**Consultation Response from KC,
Conservation and Design**

2020/94197 78, Wellhouse Green, Golcar, Huddersfield, HD7 4ET

Listed Building Consent for erection of single-storey extension to side (within a Conservation Area)

Date Responded: 03.04.2023

Proposed side elevation (1:100)

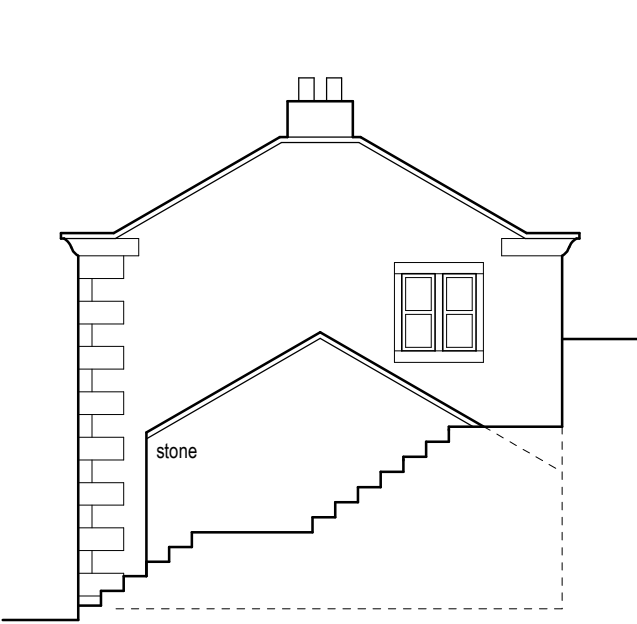
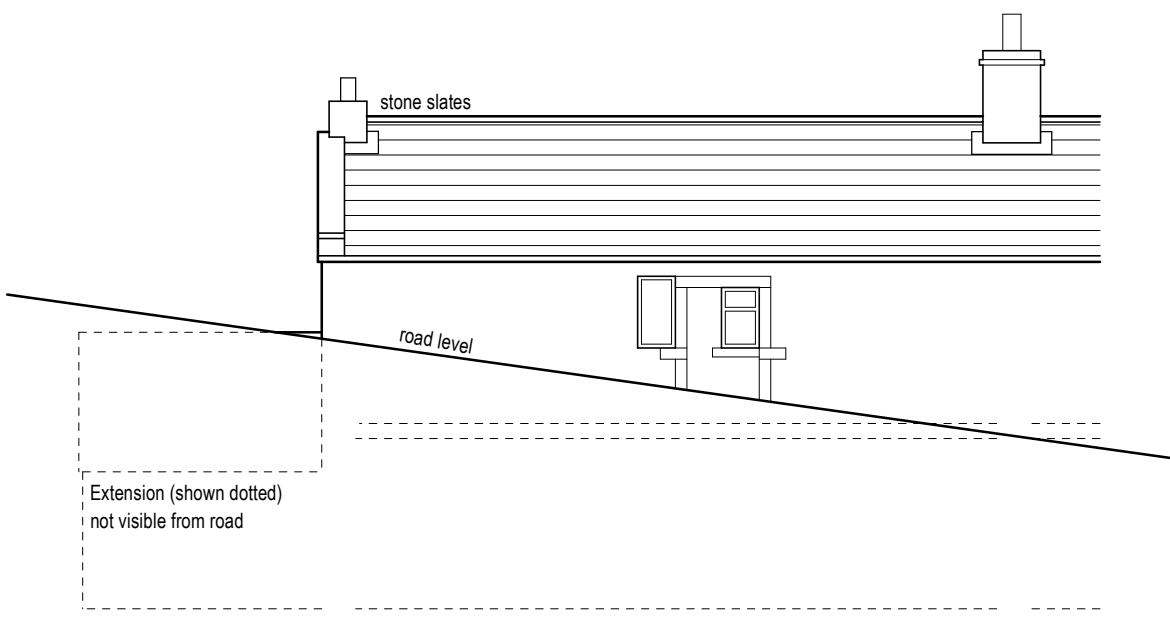
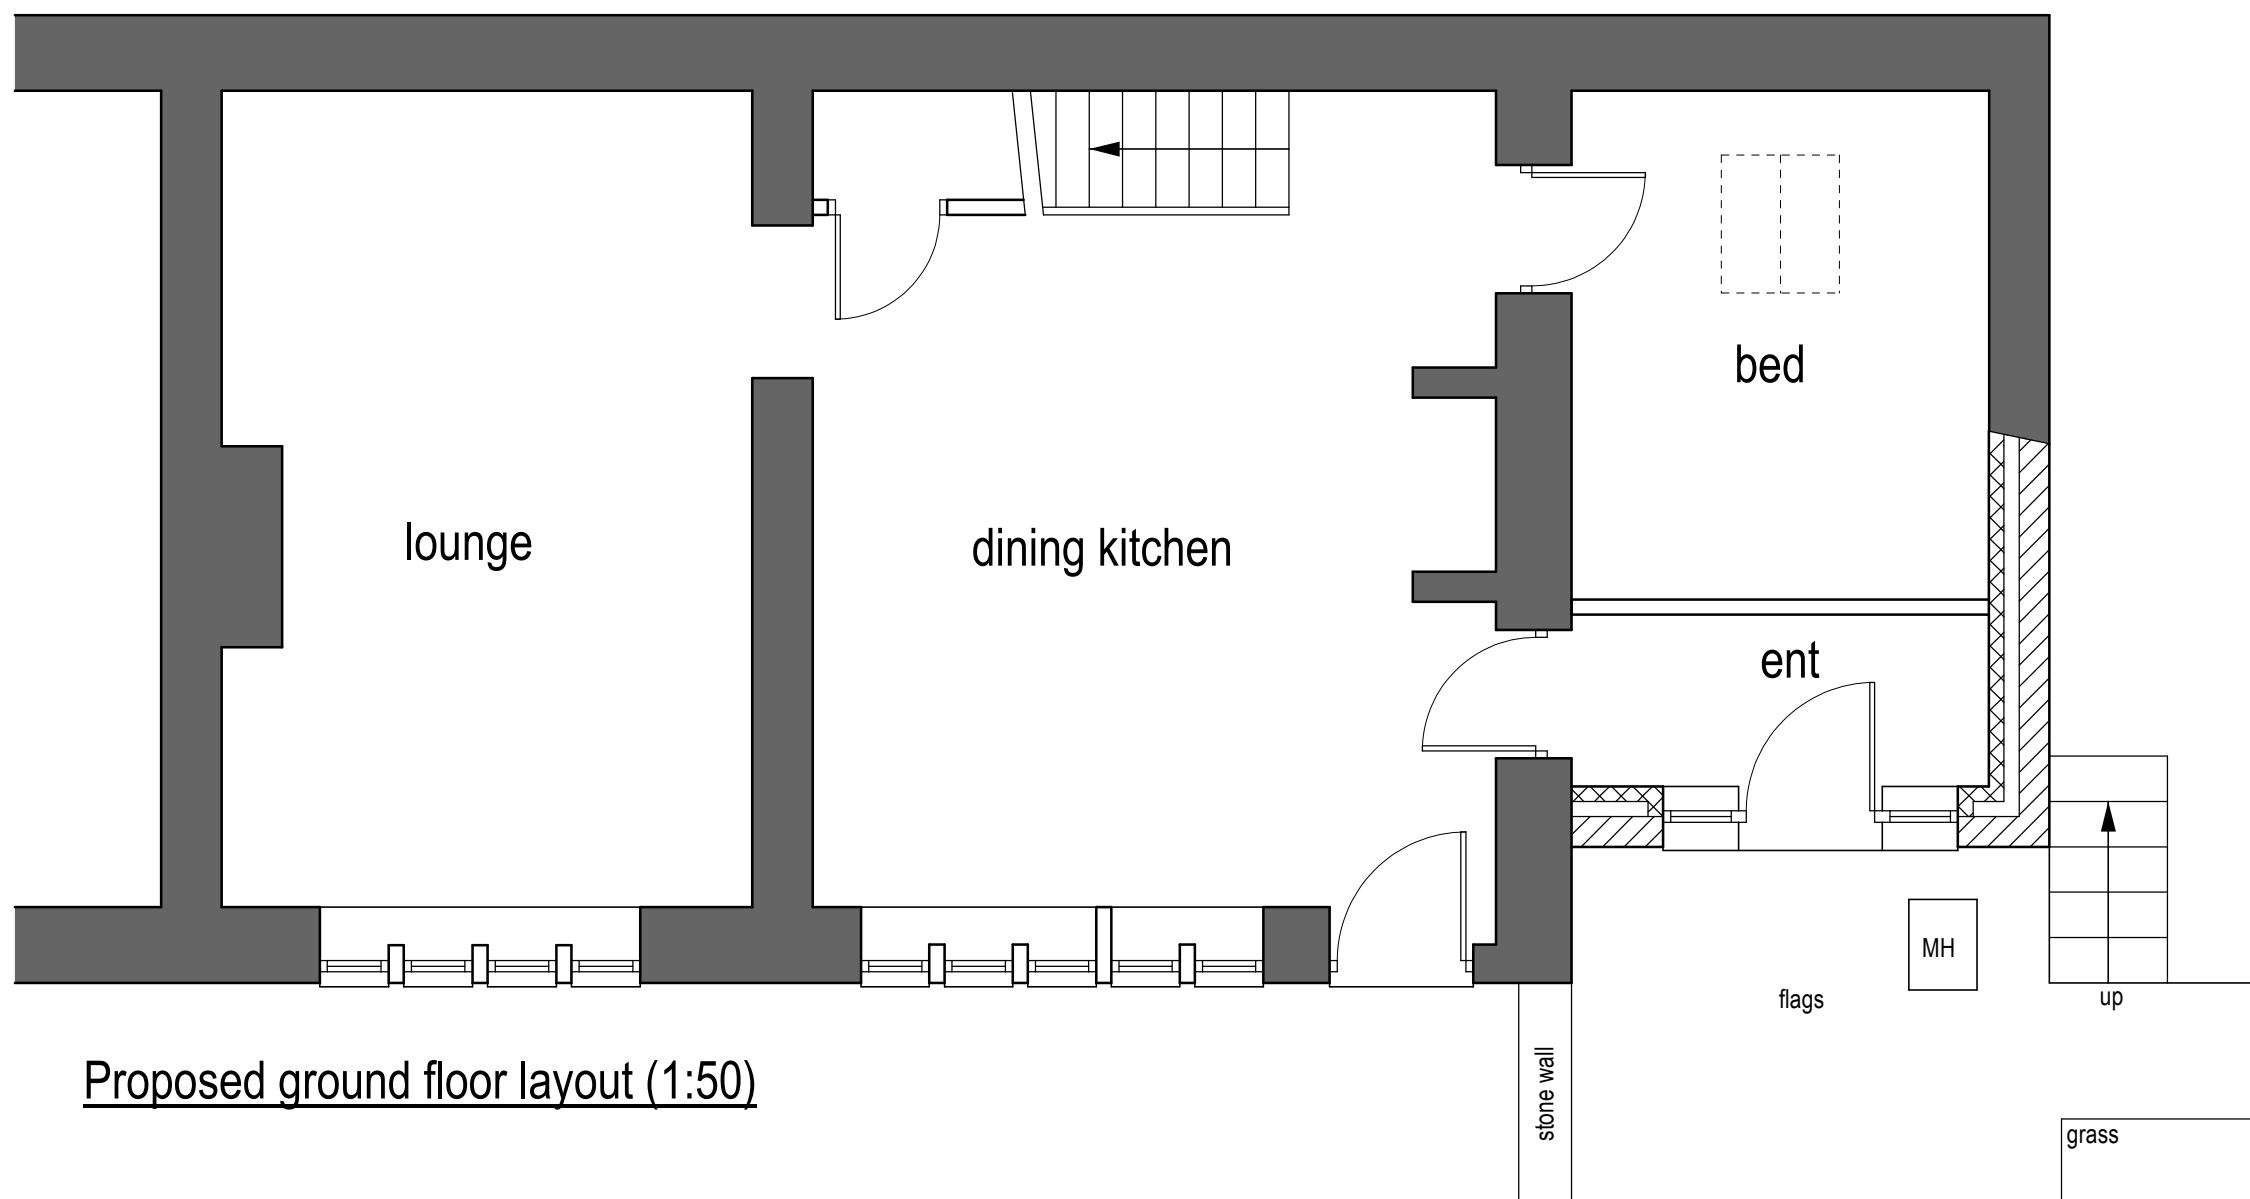
The amended plans show a proposed single-storey extension, with a pitched roof, with a gable forming on the end. We consider that the principle of the single-storey extension is acceptable, however, do consider that the detail of the extension requirements amending.

We consider that the extension needs to be amended to simply increase the lean-to extension forward along the side elevation, which follows the advice and comments previously provided.

The extension would still be set back behind the quoins. The detail to the end of the lean-to could follow the detail as existing. This would still allow for the internal reconfiguration and use of the space while ensuring an appropriate design and visual impact.
